Planning and Community Development Department - SITE PLAN

Applicant Name Craig Jasper 719-331-3464 tweetpilot@chcejasper.com
 Contractor Name Homeowner (Craig Jasper) 719-331-3464 tweetpilot@chcejasper.com
 Property Address 7250 McShane Rd, Colorado Springs, CO 80908
 Zoning RR-5 Parcel 5220007020 Legal LOT 11 BLK 5 PARK FOREST ESTATES FIL 1
 Proposed Structure & Use New 46x60 agricultural barn sq. ft. 2760 sq ft
 Lot sq. ft. 136,342 sf Existing + new structure sq. ft. 3192 sq ft % Lot coverage 2.3% height 22 feet

New Agricultural Barn
 46 X 60 Barn (2760 SF)
 Total buildings footprint: 2760+432=3192 SF

New Agricultural Barn	
46 X 60 Barn	(2760 SF)
Total buildings footprint: 2760+432=3192 SF

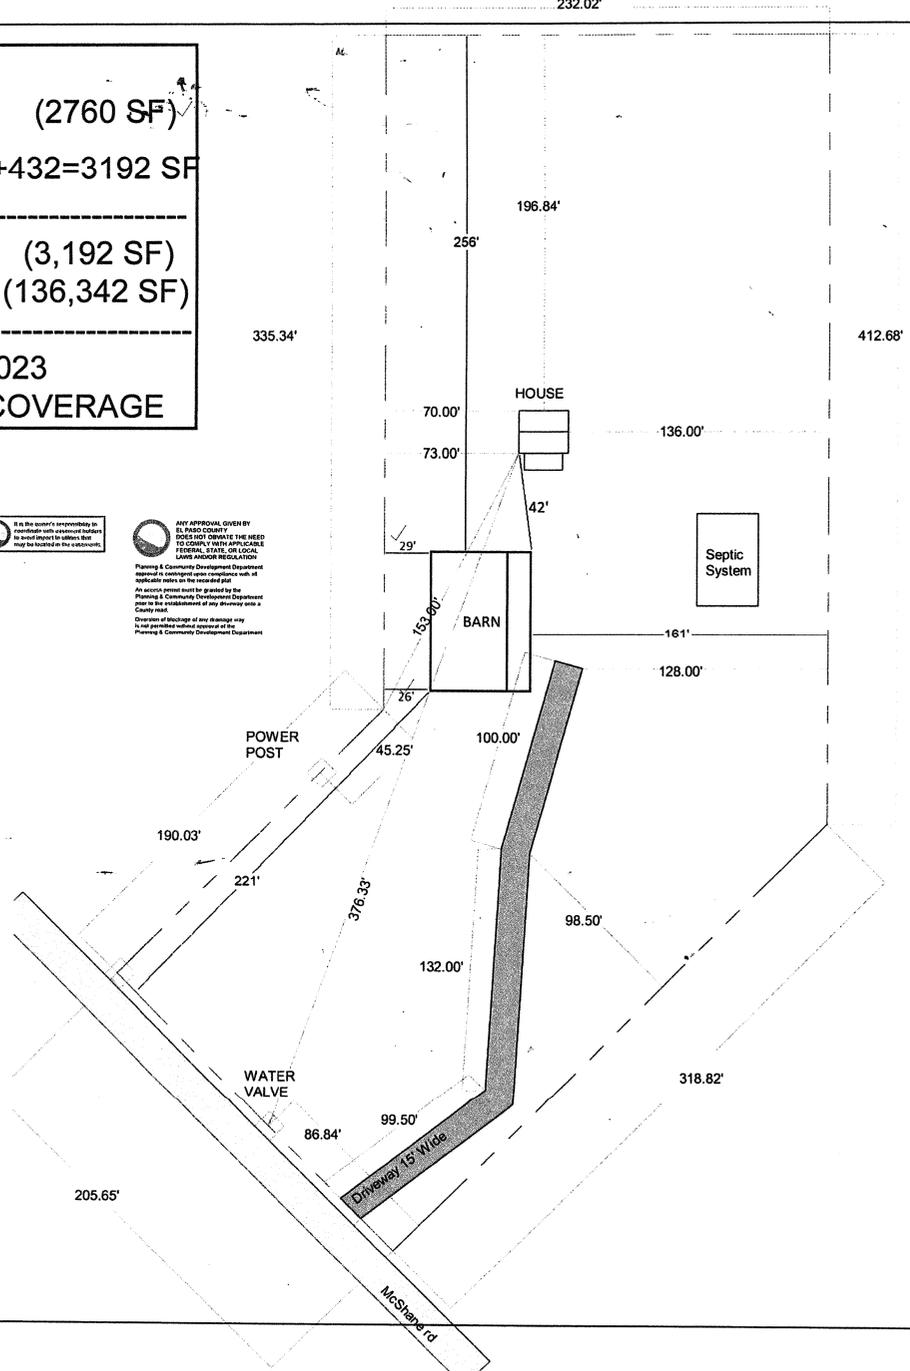
Barn is encroaching in side yard setback - 24' where 25' is required
